Application Ref:	3/2025/0394			 Ribble Valley Borough Council www.ribblevalley.gov.uk
Date Inspected:	31/07/2025	Site Notice:	31/07/2025	
Officer:	MC			
DELEGATED ITEM FILE REPORT:				APPROVAL

Development Description:	Part retrospective planning permission for proposed conversion of existing single residential flat above commercial unit into two separate flats. External alterations to include insertion of new and replacement existing side-facing windows, insertion of rooflight, alterations to existing shop front to include insertion of door and windows to ground floor front elevation and replacement of side door.
Site Address/Location:	19 and 21 Berry Lane, Longridge, PR3 3JA

Proposed Site Plan 1:200

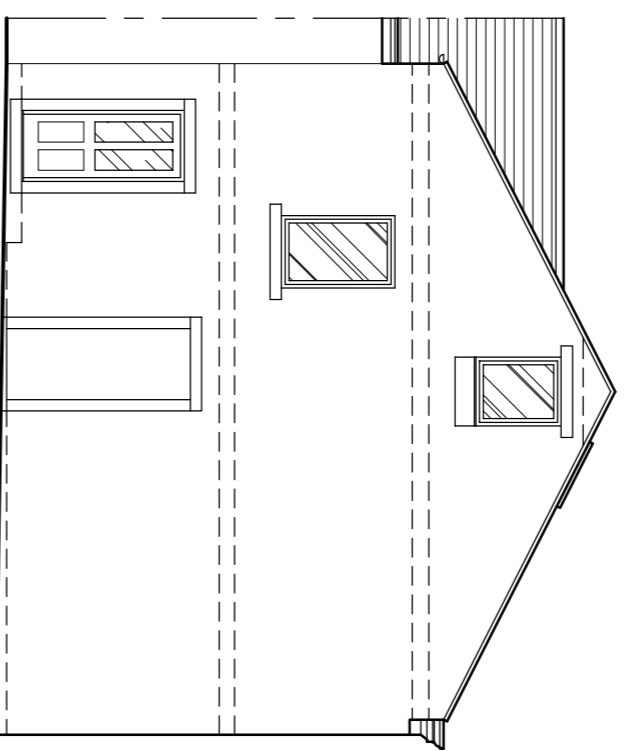
CONSULTATIONS:	Highways/Water Authority/Other Bodies
LCC Highways:	Concerns raised regarding the proposed gates to the side street which are outside of the red line boundary and would likely result in an obstruction of the highway.
RVBC Environmental Health Officer:	No objection subject to conditions relating to the submission of a sound insulation scheme, control of odour from food premises, construction noise deliveries and site preparation and construction phase control of noise/dust/fumes/vibration
RVBC Countryside Officer:	No indication of use by bats were present during the survey, either internally or externally.

The proposal previously included also the erection of entrance gates to the side of the property at Dunderdale Street, however following concerns raised on highways and design grounds, these have since been removed from the scheme.

Proposed Roof Plan

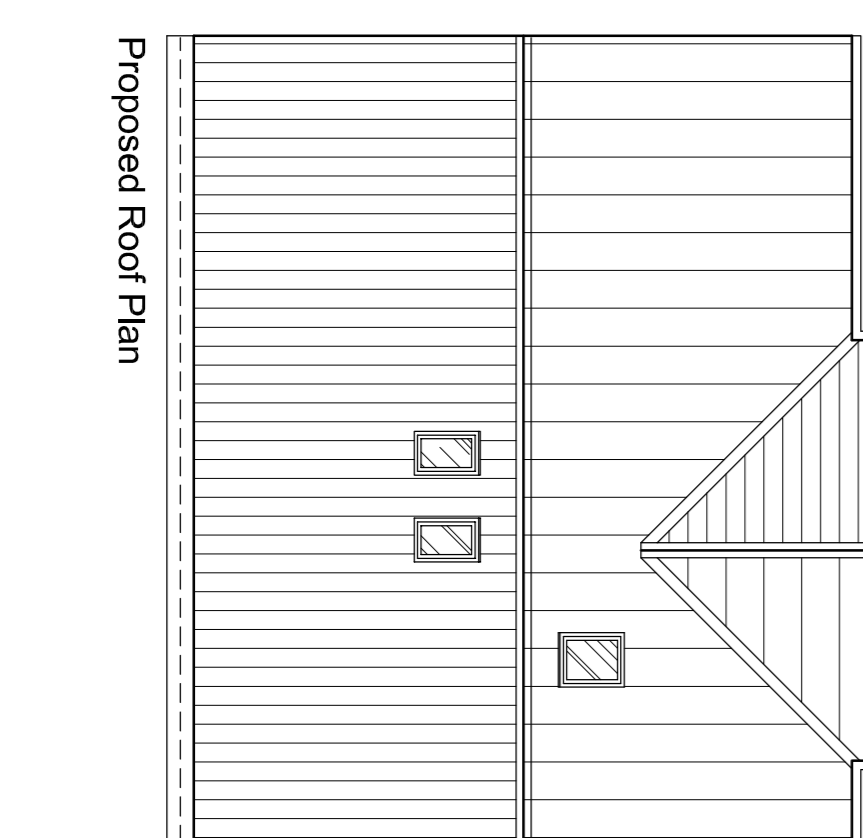
In addition, there is no objection to 1 no. additional rooflight to the front roof slope which the agent has confirmed would be a conservation style window.

In regard to materiality, the proposed works would be anthracite grey aluminium heritage windows and composite/ uPVC doors. In addition, the walls would be finished in a natural stone with new stone jambs and mullions to match the existing. The drawings have also been amended to demonstrate that the rooflight would be conservation style.
